Cockle Bay Park – Response to Agency Submissions

STAGE 1 SSDA AMENDED
CONCEPT PROPOSAL SK-4.05

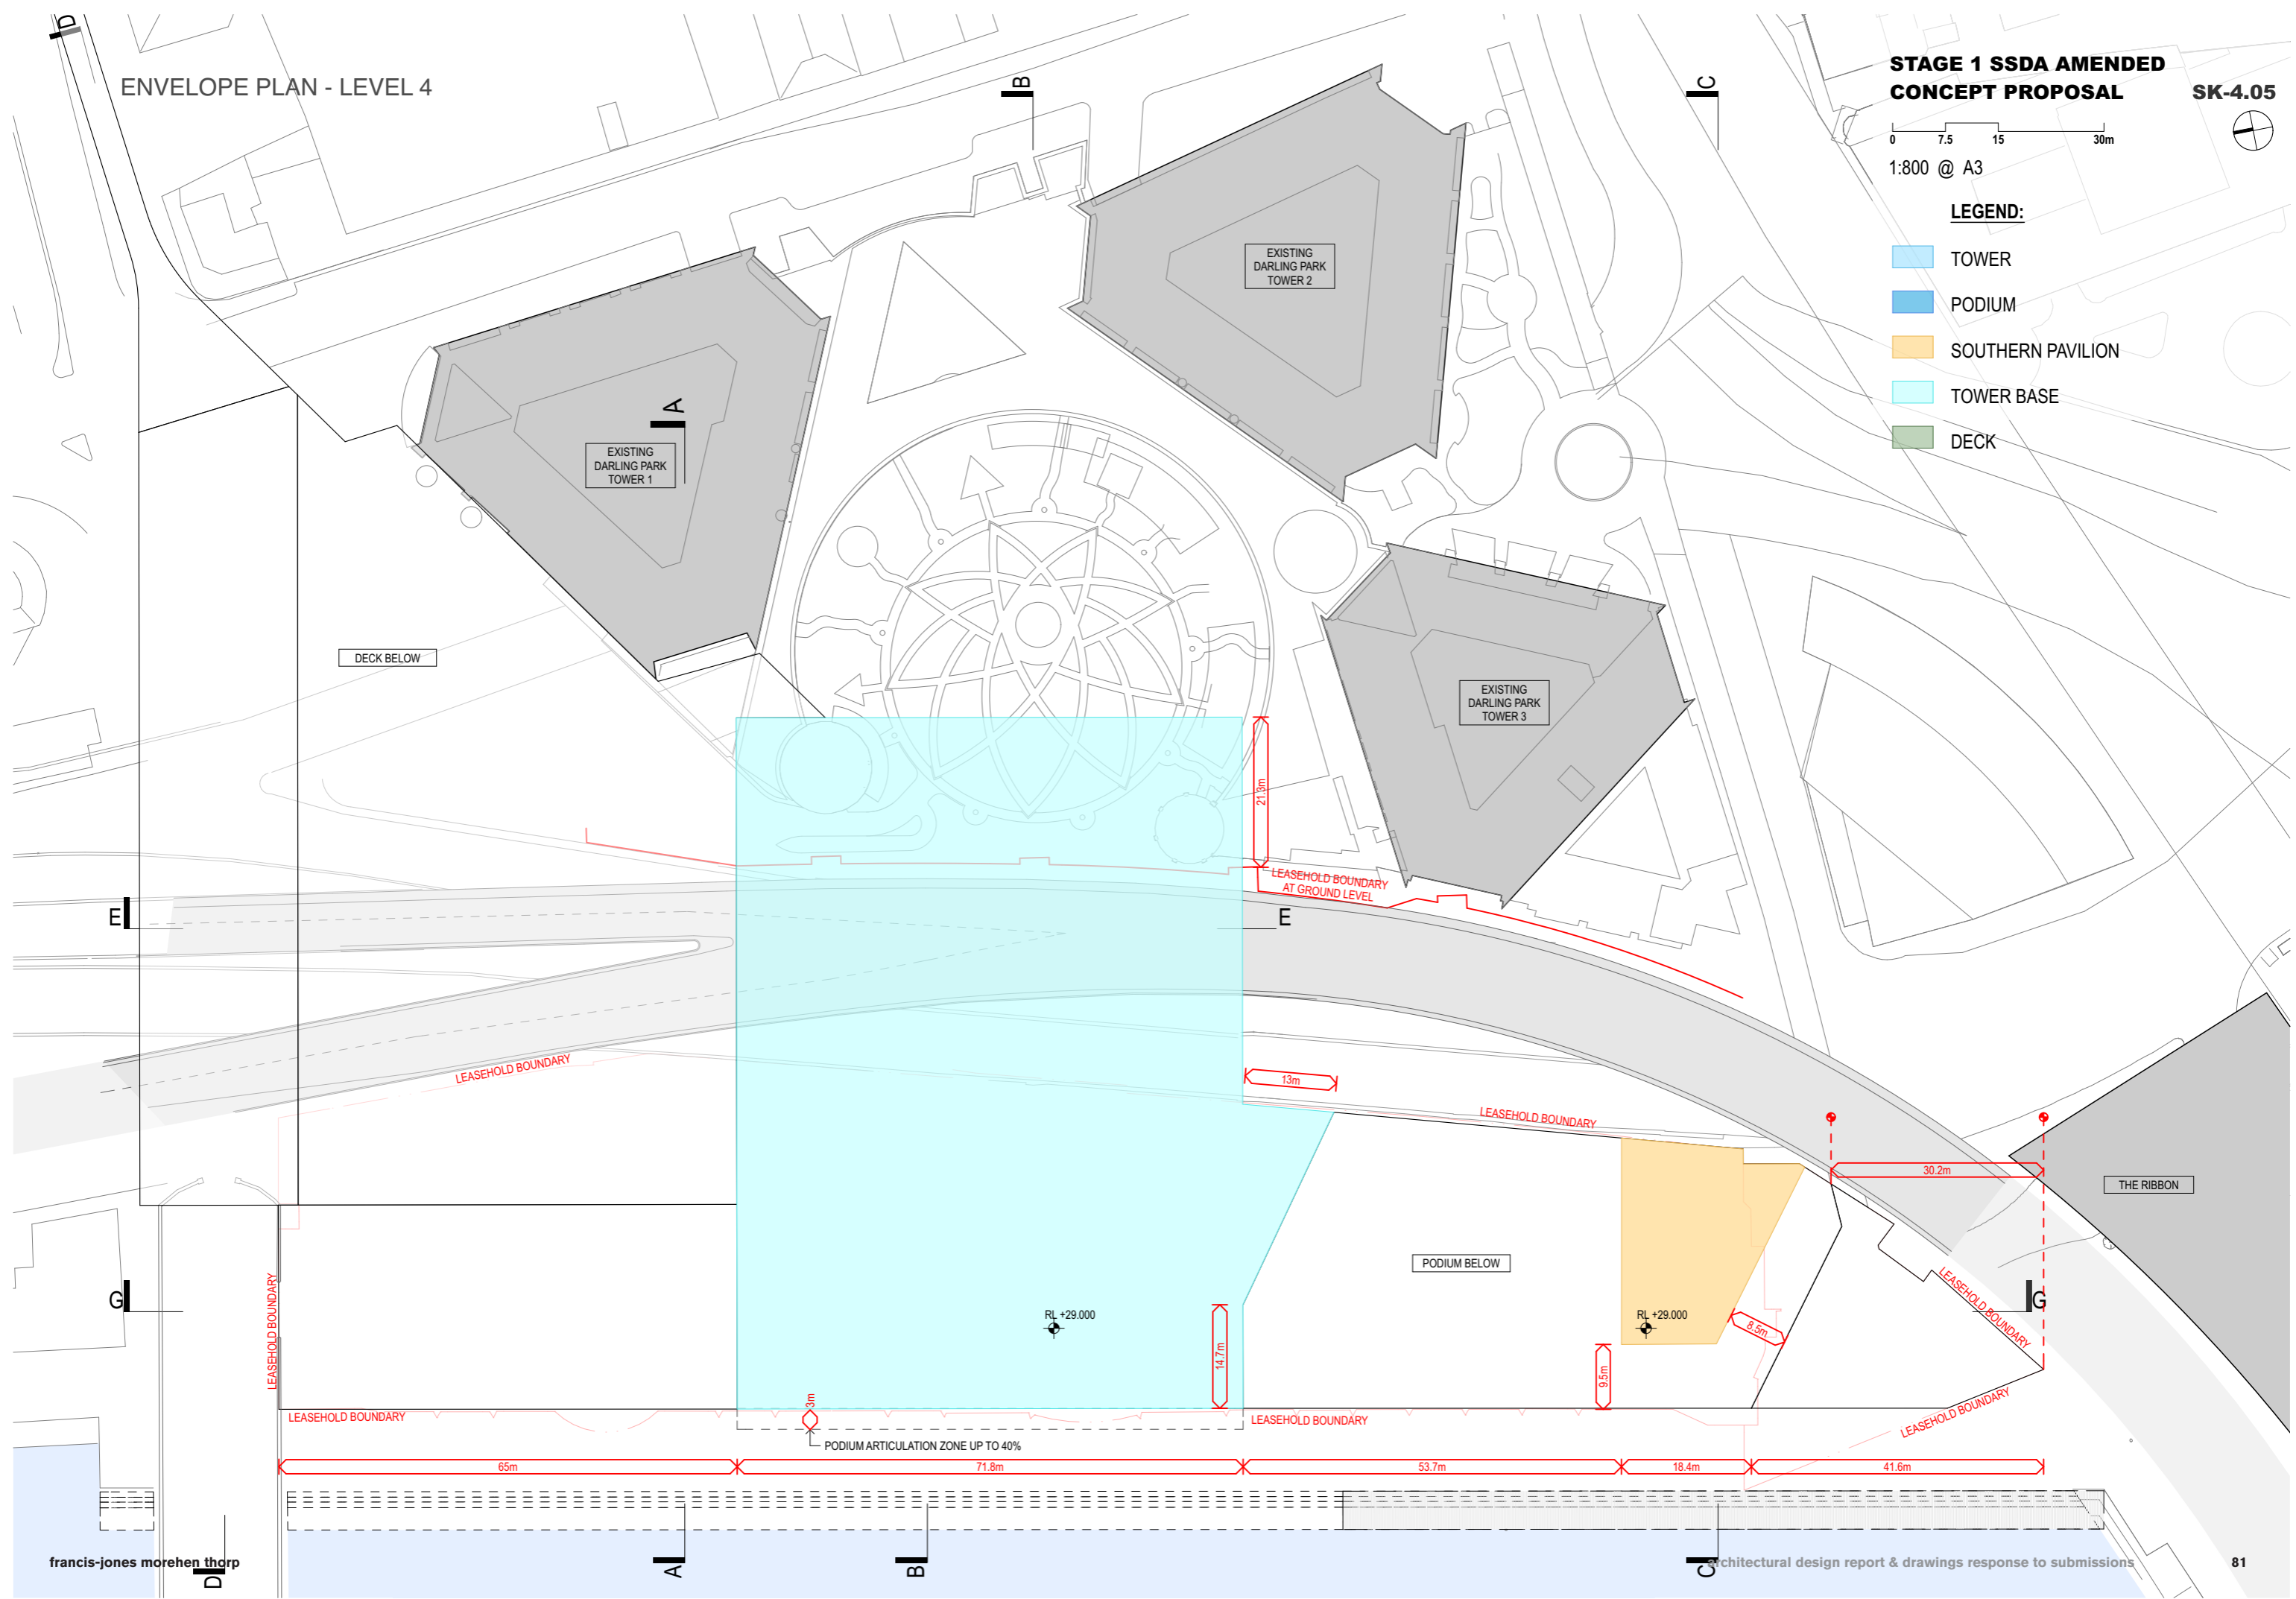
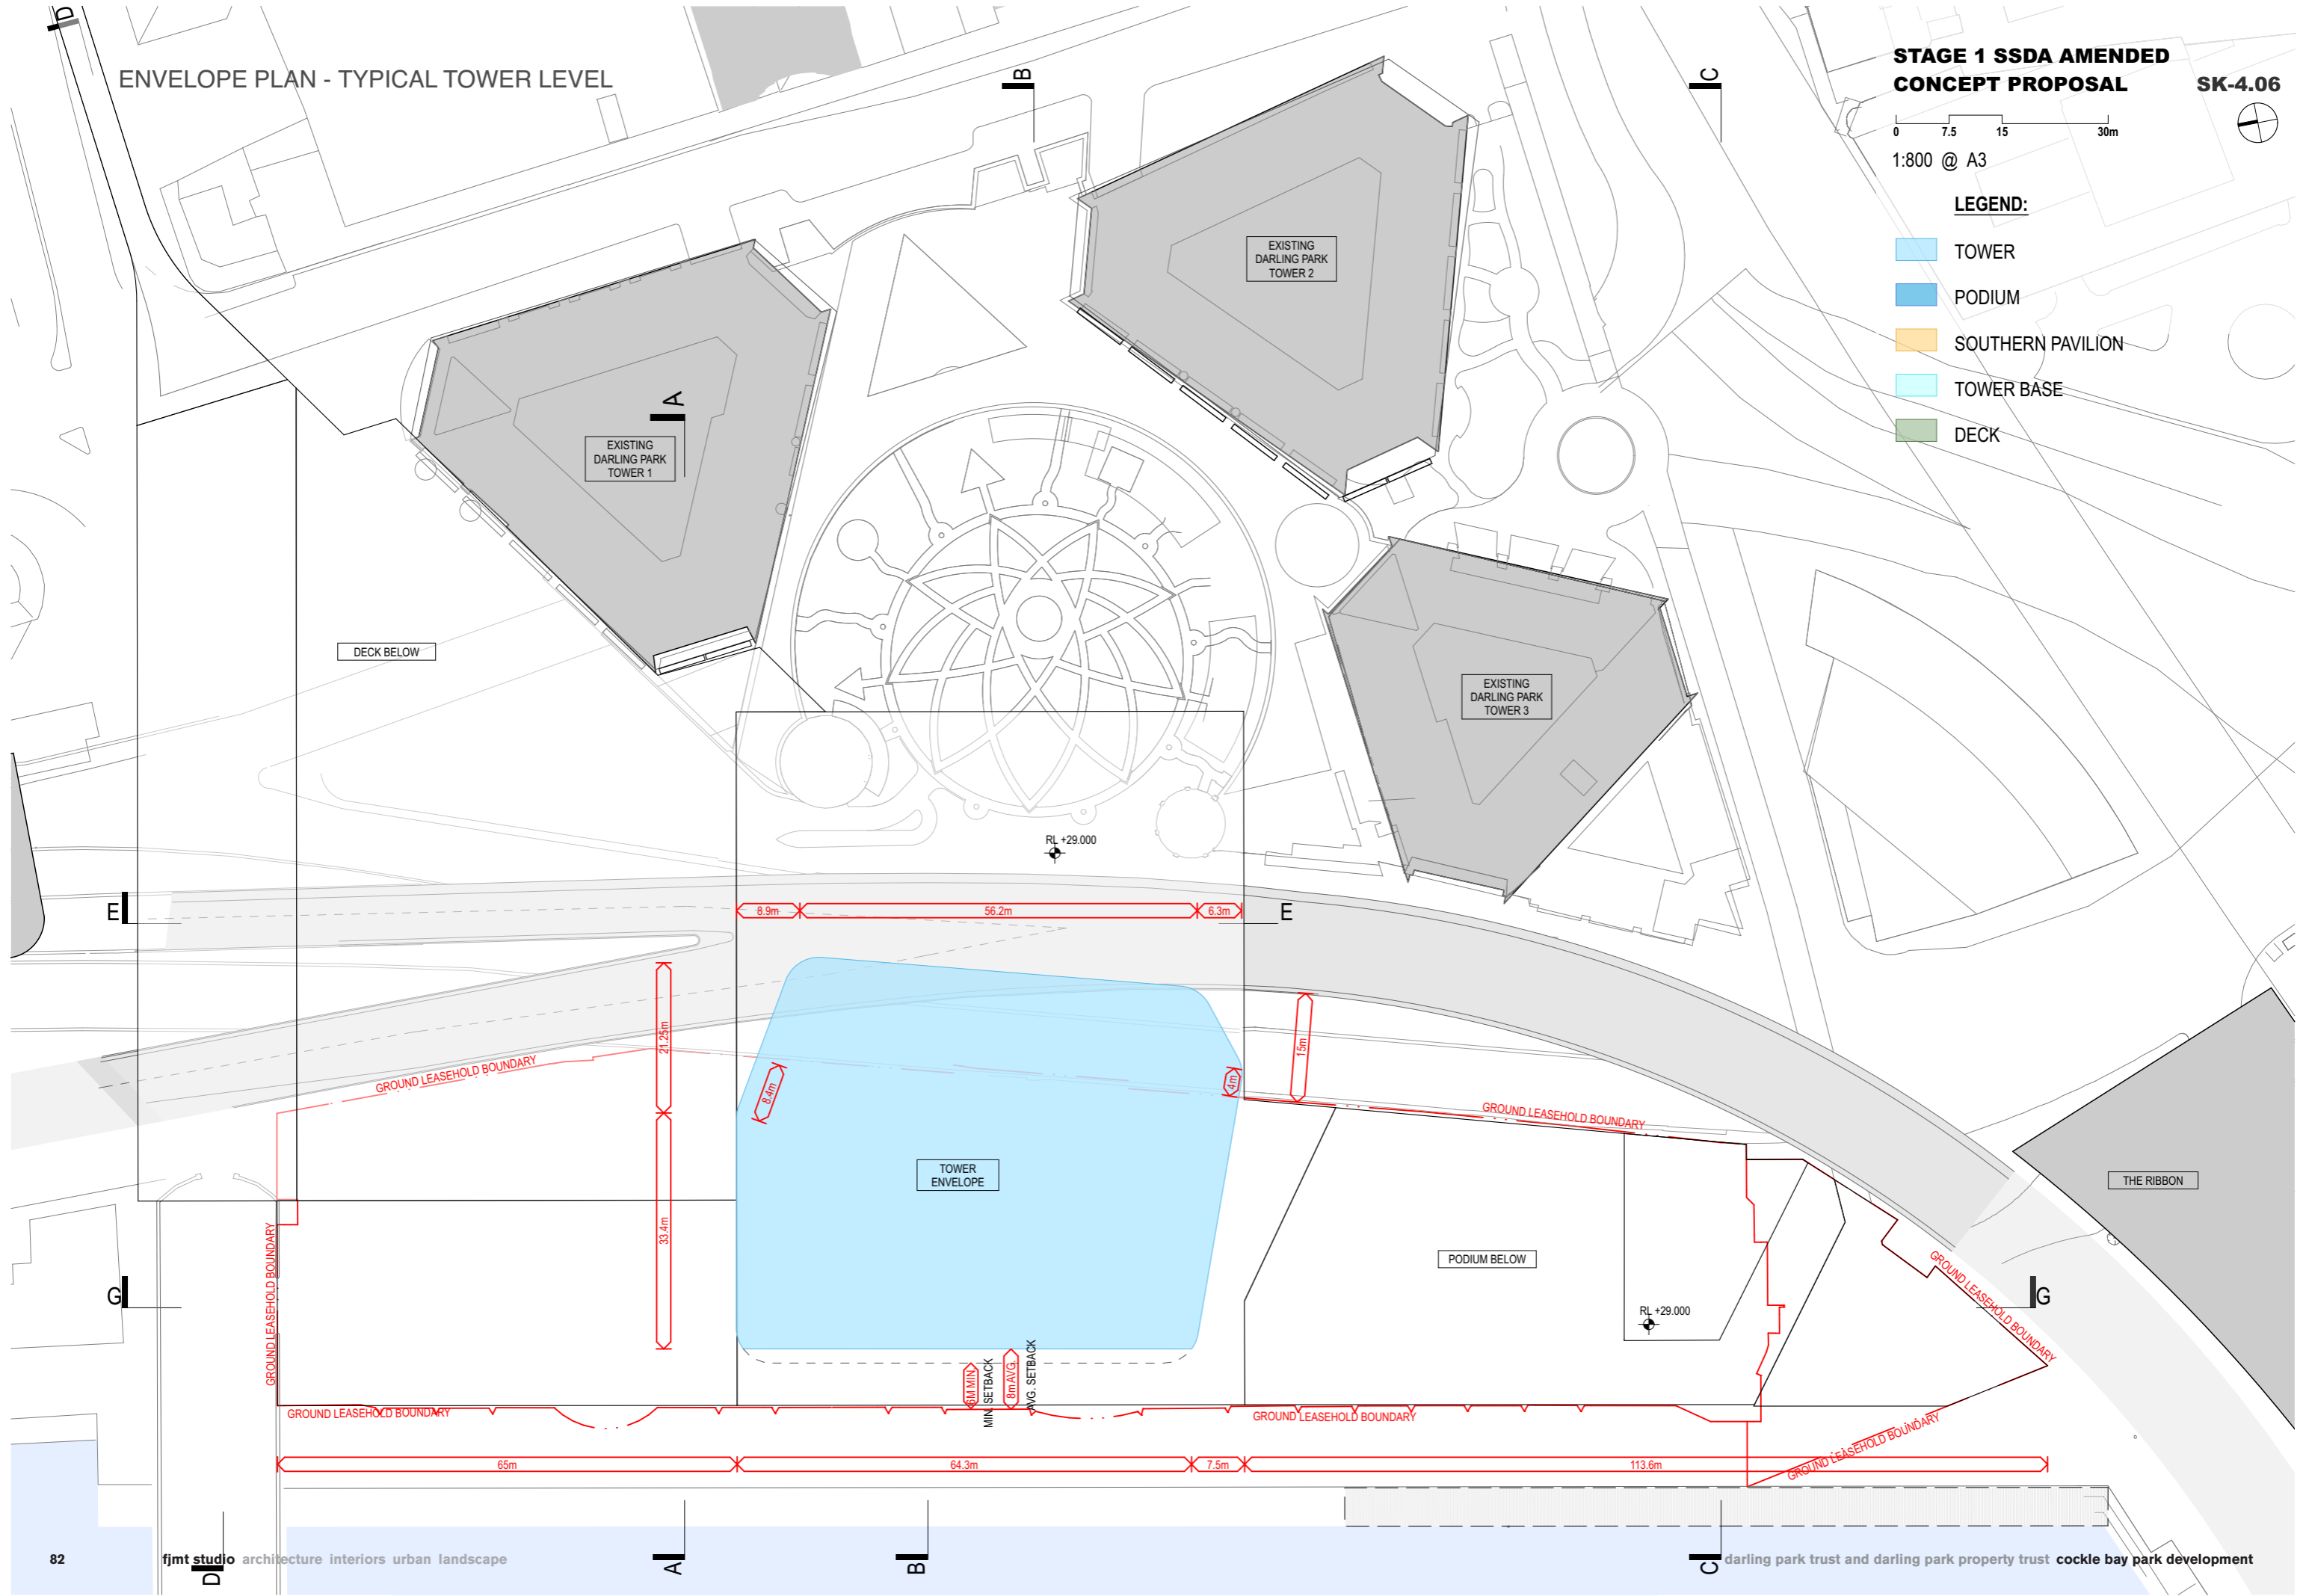
<p>The excessive bulk and scale of the proposal – the height and floor plate of the proposed commercial tower element;</p>	<p>The Concept Proposal has been amended since the exhibition of the EIS including:</p> <ul style="list-style-type: none"> • a 40 metre (17 percent) reduction in the height of the tower from RL235m to RL195m; • reduction in commercial GFA by 10,000m² (12 percent); • a reduction in retail GFA from 25,000m² to 14,000m² (44 percent); • reduction in the tower envelope footprint from 3,890m² to 3,575m² (8 percent); and

Item Raised	Proponent's Response
	<ul style="list-style-type: none"> the overall volume of the envelope has reduced by 153,000m³ (15.65 percent). <p>The amended Concept Proposal provides a proportional relationship to the existing buildings of Darling Park in consideration of height, separation and breadth so the precinct can be read as a whole. Building height and scale is further discussed at Section 7.6 and in the Architectural Design Report at Appendix C.</p>
<p>The bulk and massing of the podium and the relationship with the public domain, Pyrmont Bridge;</p>	<p>It is noted that the height of the existing Cockle Bay Wharf building is approximately RL19m, which is equal to the proposed height of the podium deck envelope. Accordingly the proposed podium at Level 3 will be of a similar scale to the existing development on Site which is considered acceptable.</p> <p>The amended Concept Proposal has revised the bulk and massing of the podium envelope to strengthen its relationship to the public domain and Pyrmont Bridge. This has been achieved through the following amendments:</p> <ul style="list-style-type: none"> reduce the volume of the Southern pavilion by reducing the height from RL31m to RL29m with the introduction of a minimum setback of between 8.5m and 9.5m from the lease boundary; increase the setback to the southern side of Pyrmont Bridge from 2m to 65m at Level 2 of the Podium; provide a new 44m (east-west) separation between the northern podium envelope (above Level 1) and the waterfront; reduce the length of the podium articulation zone along the foreshore from 209 m to 144 m, reducing the overall podium volume; include provision to extend the boardwalk (5m wide) which would further increase the spatial relationship between the podium and waterfront; and consolidate publicly accessible open space adjacent to Pyrmont Bridge. <p>The amended Concept Proposal will elevate the significance of the public domain by knitting the Site</p>
